**RE: Falcon Area Water and Wastewater Authority  
Sterling Ranch Water Treatment Plant  
Site Development Plan – Comment Response Letter  
PPR-23-014**

Below are responses to comments provided 10/2/23 – 10/4/23 for agency review of the above-referenced project. We have inserted our responses and actions taken in **blue** below each comment.

FALCON AREA WATER AND WASTEWATER AUTHORITY - WATER TREATMENT PLANT
GRADING AND EROSION CONTROL PLAN
DESIGNED BY JDP SCALE DATE 3/28/23
DRAWN BY JDP (H) 1"= 30' SHEET 2 OF 4
CHECKED BY KRC (V) 1"= N/A JOB NO. 1307.00

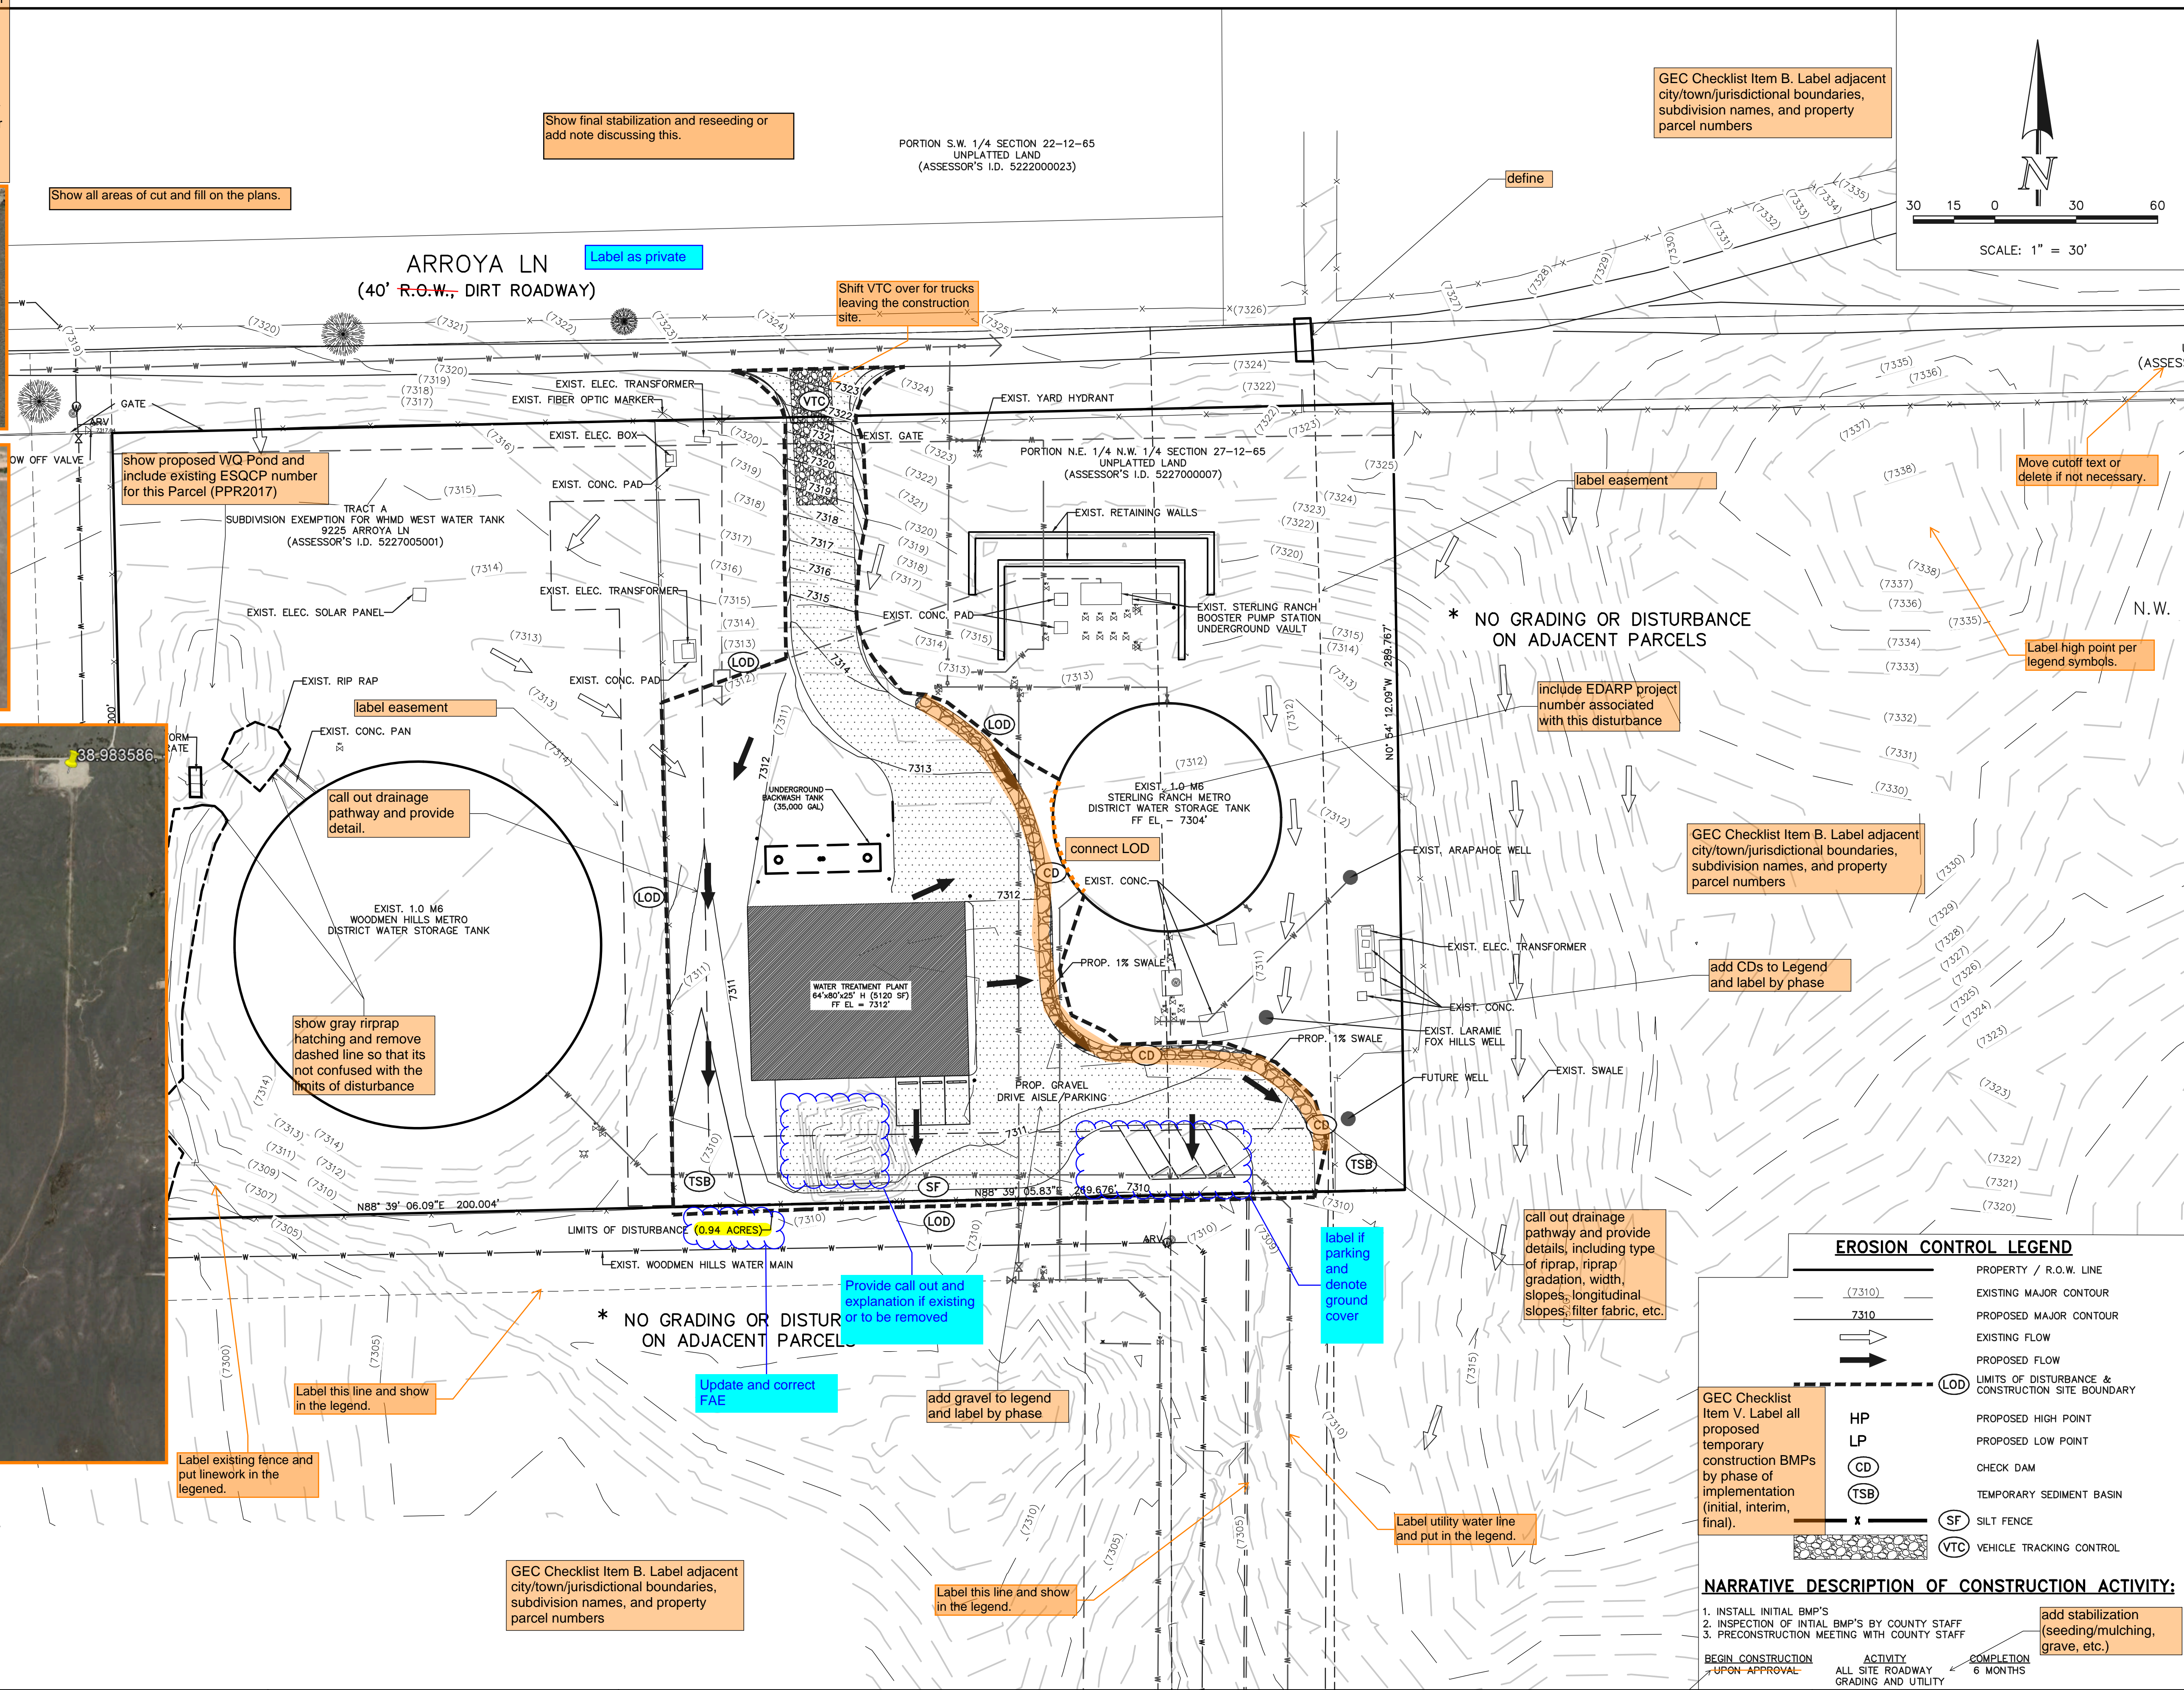
5. Comment on GEC Plan: "The off-site disturbance does appear to be somewhat revegetated per the GEC responses doc submitted. The project site area still appears to have significant disturbance based on a NearMap aerial from mid-August. You can keep the linework for the construction limits, but the disturbance limits should account for the entire lot or majority to account for the prior disturbance and the disturbance area should reflect this larger disturbance. This whole area will require reseeding. This area outside of the construction limits can be excluded from treatment using Exclusion G on the PBMP form, and the construction area is still <1ac so no permanent treatment facility will be required, just an ESQCP."

6. Comment on GEC Plan: "Show all areas of cut and fill on the plans."

**An updated GEC plan has been submitted including a larger disturbance area which accounts for prior disturbance on site. This area has been noted as requiring reseeding.**

**All areas of cut and fill are indicated on the updated GEC Plan.**

NO.	REVISION	DATE
1	REVISED PER COUNTY COMMENTS	8/7/23

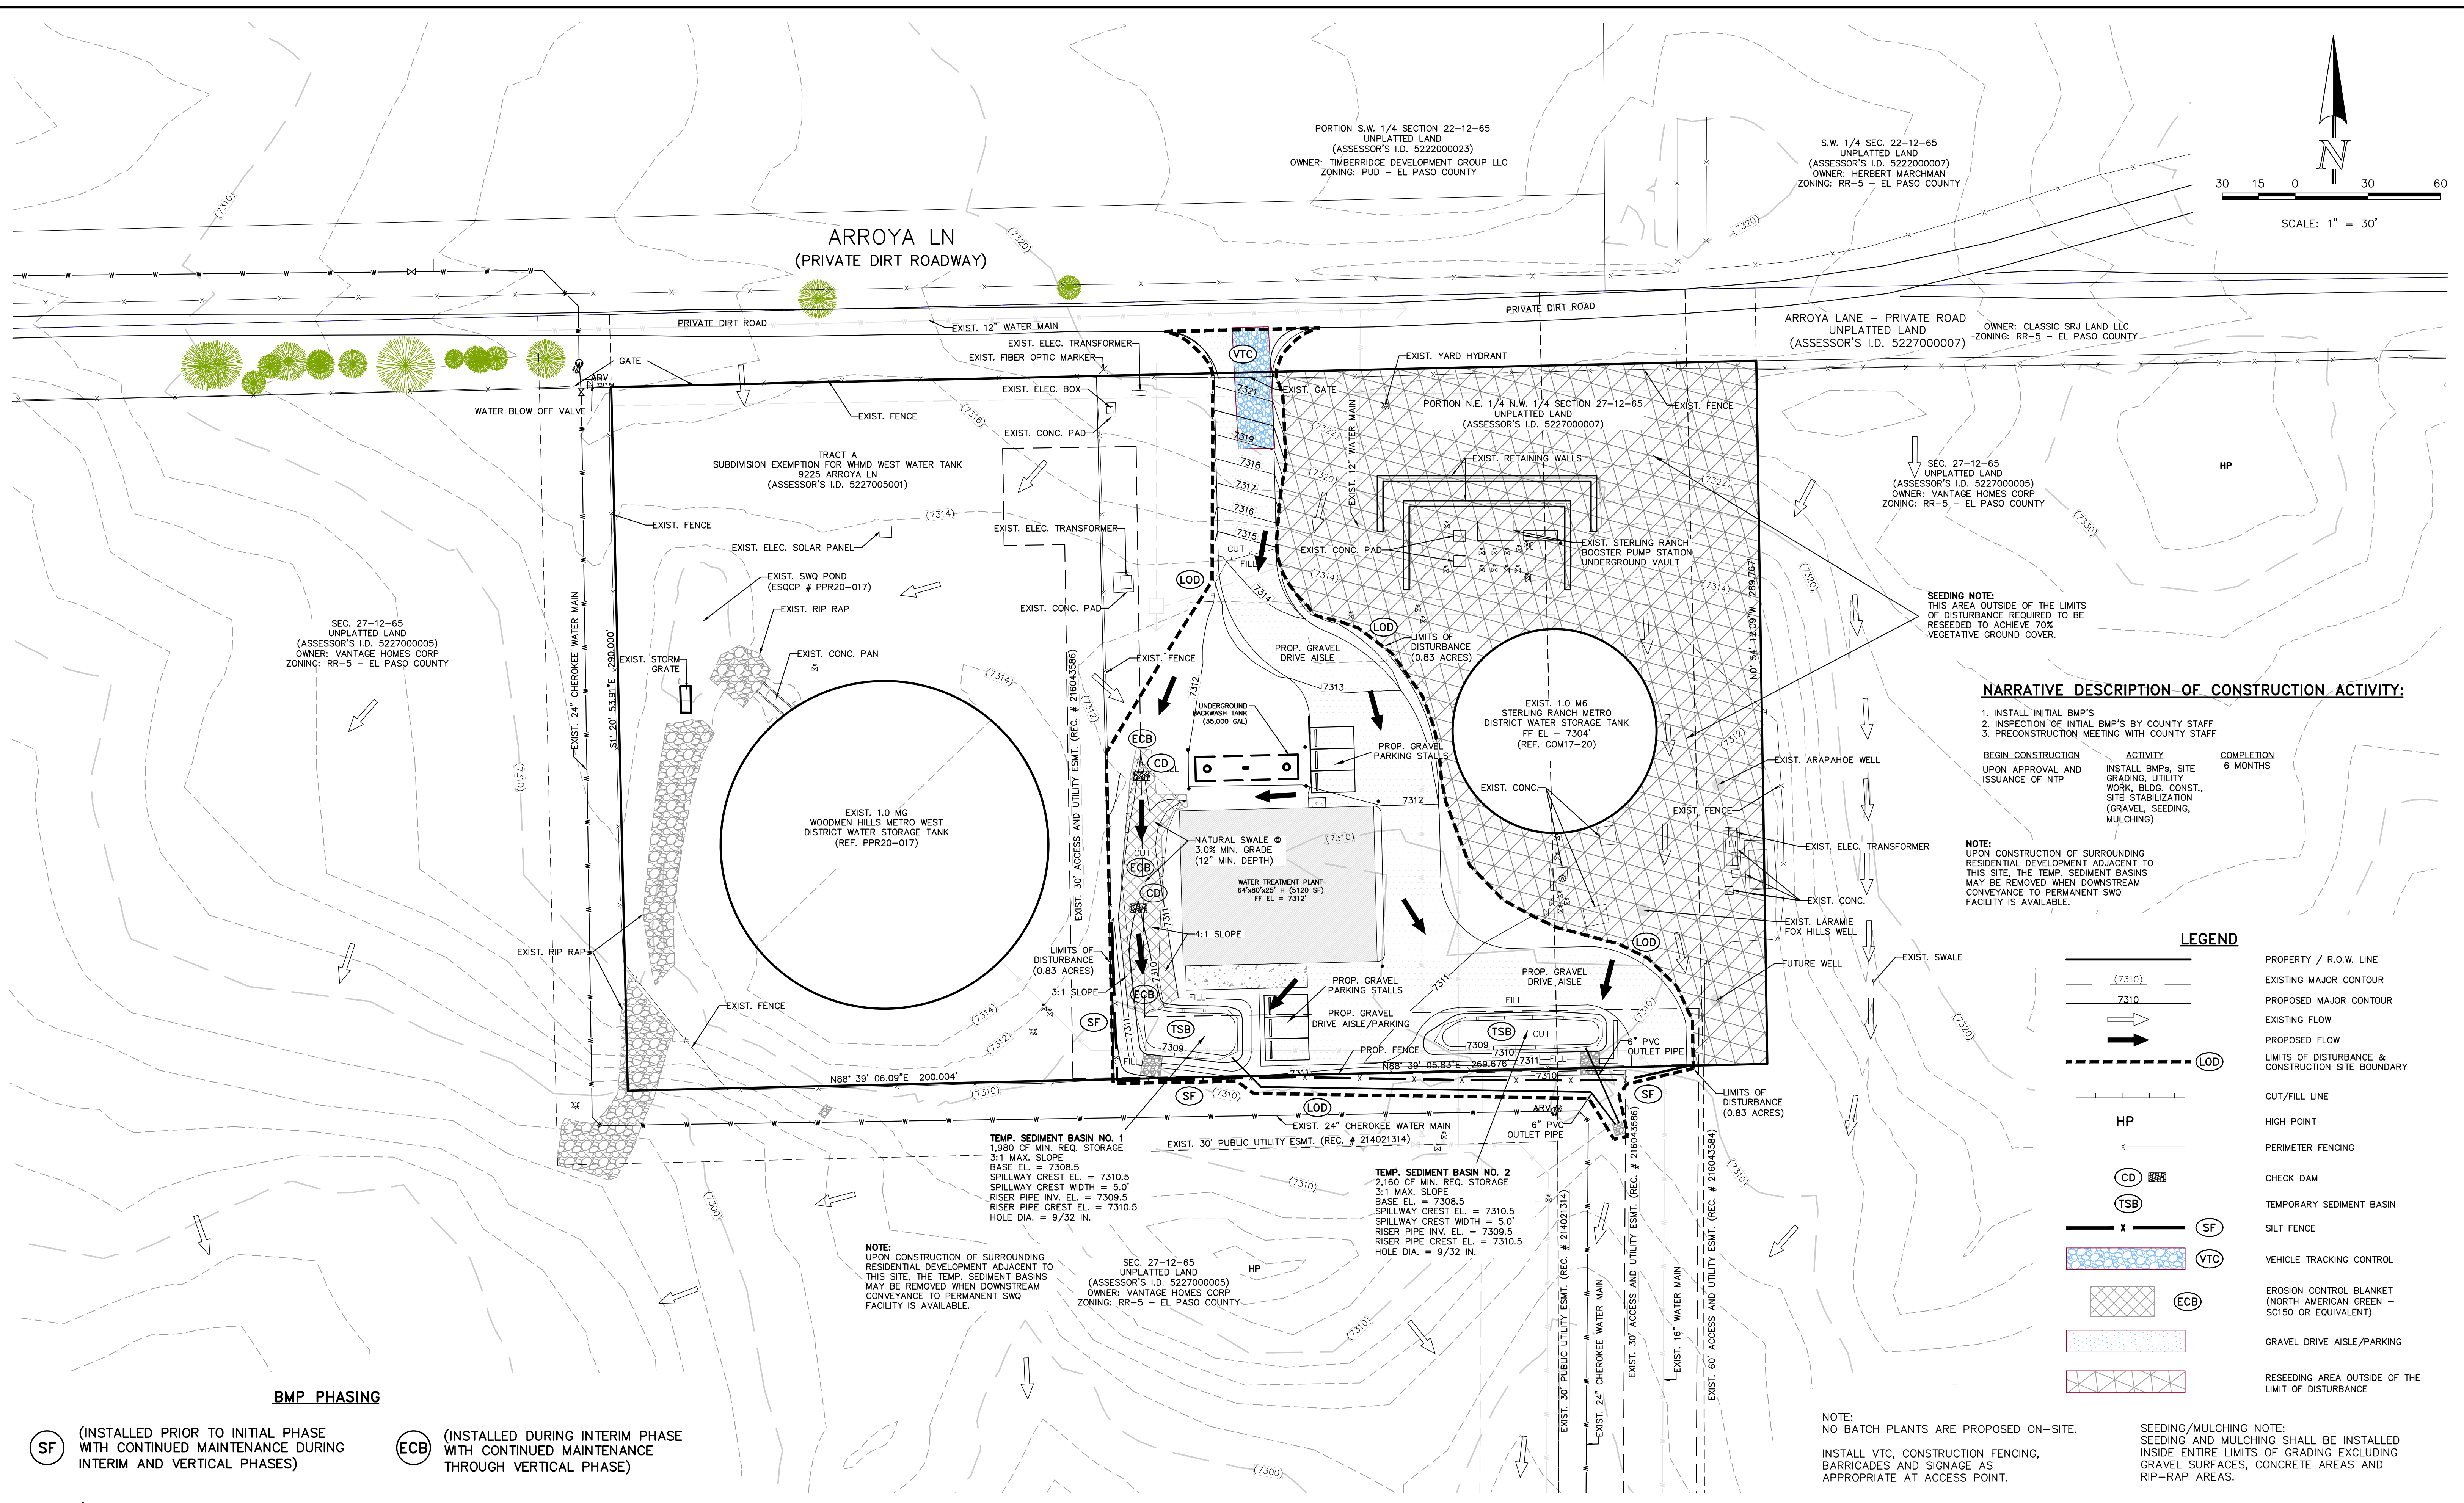
7. Comment on GEC Plan: "Show final stabilization and reseeding areas."

8. Comment on GEC Plan: "Call out drainage pathway and provide detail (ditch cross-section)."

10. Comment on GEC Plan in reference to sedimentation basins: "Are these permanent or temporary? Permanent BMPs can be used but will not be required per the above comment. For temporary sediment basins, consider using a sediment trap since the site is less than 1 acre."

**Reseeding and mulching areas are noted on the updated GEC Plan as being installed inside entire limits of grading excluding gravel surfaces, concrete areas, and rip-rap areas.**

**The updated GEC plan includes drainage pathways and details for silt fences and check dams to be included in drainage ditch.**

**The sedimentation basins are temporary and are labeled as such in the updated GEC plan. The updated plan also indicates the location of a silt fence around the basin.**

D SUMP PUMP
PL3 SCALE: N.T.S.

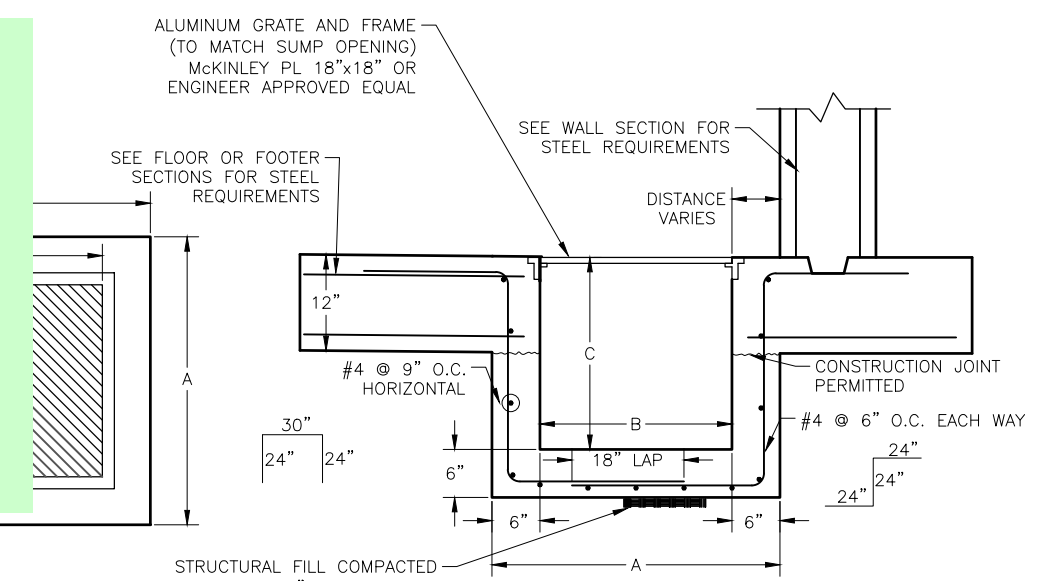
1. Plumbing plan submitted instead of Lighting Plan.

**The Lighting Plan has been submitted including the following required elements:**

- a. Owner name, contact telephone number, and email address
- b. Property address
- c. North arrow and graphic scale
- d. Height of all proposed illuminating devices
- e. Photometric data including maps and diagrams furnished by manufacturers
